**KIRKLEES METROPOLITAN COUNCIL
INVESTMENT & REGENERATION SERVICE**

DELEGATED DECISION TO DETERMINE PLANNING APPLICATIONS

Reference No:	2023/62/91591/W
Site Address:	6, Grimscar Avenue, Birkby, Huddersfield, HD2 2TU
Description:	Erection of single storey rear extension and installation of dormer windows to the front and rear (within a Conservation Area)
Recommending Officer:	Sam Jackman

Officer Report – 2023/91591

Ground Floor Layout 1.50

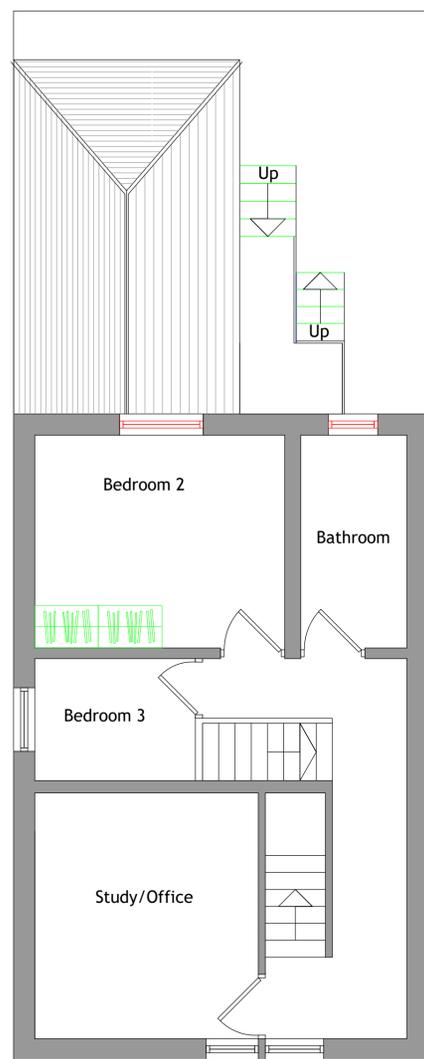
With regards overlooking of this property, the proposal includes a window overlooking the amenity space of no.4. Therefore, given that the window is only 2.5m away and as already stated is higher due to the changes in levels than if to a flat site. No adequate screening could be provided to prevent overlooking, it is noted this is to a non-habitable room however, once built the layout could change by the bathroom not been included allowing for a larger dining kitchen which would be a habitable room.

Therefore, overlooking would occur both of the garden area and due to the angle and relationship between the proposed window and neighbours' property, there would be overlooking of the neighbours ground floor window.

Roof Layout 1.50

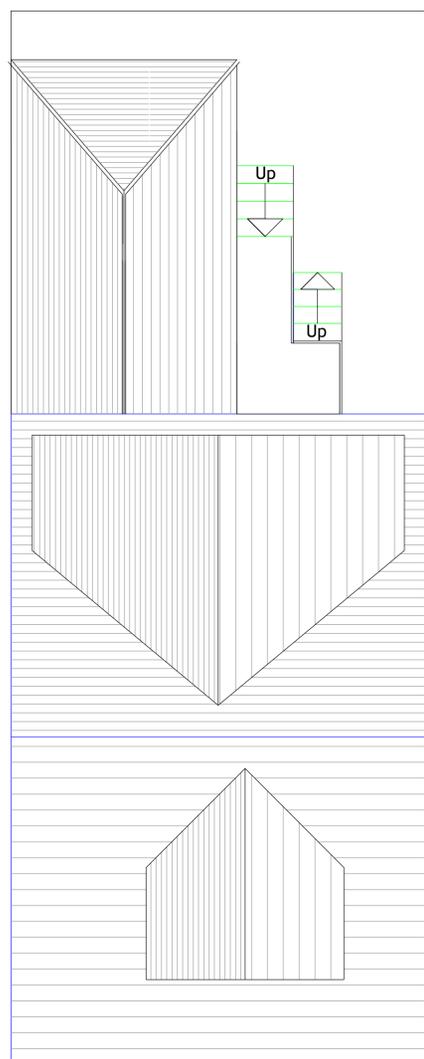
With regards the dormers they are both set in from the shared dividing wall and are unlikely to create any overbearing or over shadowing of this property given the size and position of the dormers.

With regards the dormers they are both set in from the shared boundary, where it is accepted that No 8 is at a lower level and north of the host property. It is considered the front dormer is unlikely to create any overbearing or over shadowing of this property given its size and the same with regards the rear dormer albeit the dormer is larger, the additional impact is considered to be minimal.

Front elevation 1.100

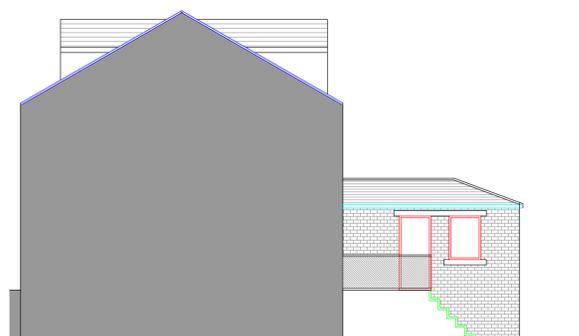
The application also includes a front & rear dormer to the property, where very few front dormers exist within the immediate area, therefore, consideration to its design and size is paramount in order to protect the character of the property and area within Birkby Conservation Area.

The front dormer would be set back from the gutter approx. 0.6m and approx. 0.3m from the ridge both measured in the vertical plane. The dormer would have a pitched roof and centrally located within the roof space covering just over 50% of the width of the roof. Where centrally located dormers are preferred, in this case the dormer may be more acceptable if off-set to the right so that it sits above with the existing windows and the roof light is moved to the opposite side. However, this would impact on the internal layout of the room, given the position of the staircase. Finally, materials haven't been specified, these could be conditioned if the proposal was considered to be acceptable.

However, it is considered, on balance, that the front dormer would be not be an acceptable addition in this location, with regards its size and design. This conclusion is drawn on the basis that the roofscape in this locality does not see dormer features within the roof slopes. Given that dormers cannot be installed within roof scapes under permitted development, and the prominence if the site / this proposed element of the scheme, it is concluded that the proposed front dormer would have a detrimental impact to the character of the Conservation Area leading to less than substantial harm.

It is concluded that the proposed front dormer would have a detrimental impact to the character of the Conservation Area leading to less than substantial harm.

With regards the dormers referred to above, the front dormer would introduce a dormer feature to the front roof slope, where there are no such features in the area and wider street scene. The rear dormer is considered to be large in scale and would dominate the roof slope given its width. The shallow pitched roof would also not reflect or harmonise with the host property.

Side elevation 1.100

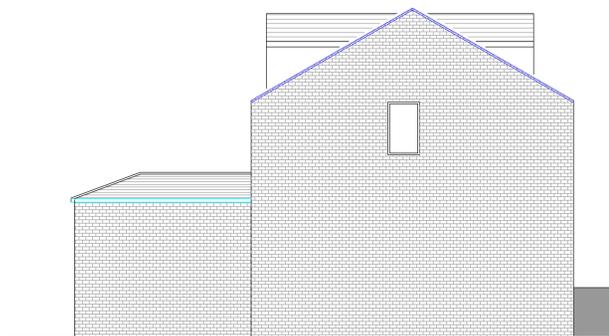
The proposed extension does not preserve or enhance the character of the conservation area as it introduces a dominant extension given its height and projection and with a shallow hipped roof. The scale of the extension does not respect the surrounding character or street scene and is considered overbearing.

The rear elevation of the proposed ground floor extension has been designed with a blank gable to prevent overlooking of the rear gardens to Bleasdale Avenue which would be acceptable regarding overlooking, however, from a design point of view given its overall height adds no benefit to the character of the extension or enhances the features of the host property but would dominate it. This is exacerbated by the fact that the north facing elevation is also a blank wall.

However, as noted above, it is considered that the proposed extension at No 6 Grimscar Avenue would be an overly prominent feature within the street scene given the sloping site, the overall scale of the extension and its proximity from the rear boundary, thereby causing detrimental harm to the visual amenities of the locality. Furthermore, it is considered by virtue of its overall scale (notably length) and its very shallow roof, it would appear as an incompatible feature with the existing dwelling.

This property is located due north of the host property, where in this case the proposed extension would be built on the boundary almost the full depth of their garden. Given the topography of the area the extension is 4.5m high. Therefore, given the height and depth of the extension built on the shared boundary, it is considered the extension would have an overbearing and overshadowing effect on the occupiers of this property when using their outside space.

There would be less of an impact on the internal space given the elevated position of the neighbour's window, however, the extension still wouldn't comply with the 45° rule of the SPD, reducing daylight and have an overbearing impact. The windows close to the proposal, in the rear of no.8 would be most impacted upon by the proposal and it is considered the scale of the proposal would have a harmful impact to the occupiers of this property.

Rear elevation 1.100

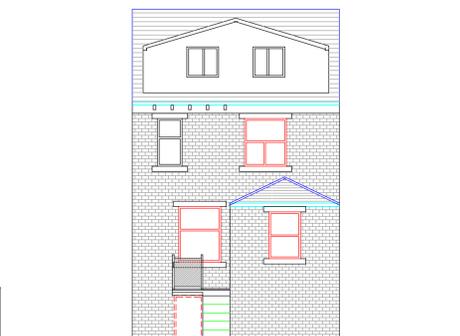
With regards to the rear dormer which would in some cases be permitted development, given that the property is within a Conservation Area, the rear dormer requires planning permission. In addition rear dormers are more likely to be less visible from the street, however, in this case given that Bleasdale Avenue runs adjacent to the gable of this pair of semi-detached properties the rear dormer will be clearly visible from the public viewpoints.

The rear dormer is set down from the ridge and back from the gutter. It is set in from both sides but would extend almost 90% of the roof width, again has a pitched roof but a shallow one, which is not in keeping with that of the pitch of the roof slope of the host property. Again no materials have been specified, which could be conditioned if the dormer was considered to be acceptable.

The introduction of the hipped roof with a lower pitch reduces the potential bulk of the extension but doesn't reflect the steep roof slope of the host property. Albeit it is accepted a steeper pitch may not be achievable due to the first-floor windows, this doesn't justify the design being acceptable in this case.

With regards to the rear dormer which would be visible from the rear gardens of these properties along Bleasdale Avenue, however, with a separation distance of 8.5m it is considered there would be no undue overbearing or overshadowing of these properties. With regards overlooking, it is accepted the rear dormer window would look in the direction of these properties but given the topography of the area, the view would be over the roof tops therefore, limited overlooking would occur in this case. Therefore, the domers would comply with policy LP24, Chapter 12 of the NPPF, as well as principles 5 and 6 of the Kirklees House Extensions and Alterations SPD.
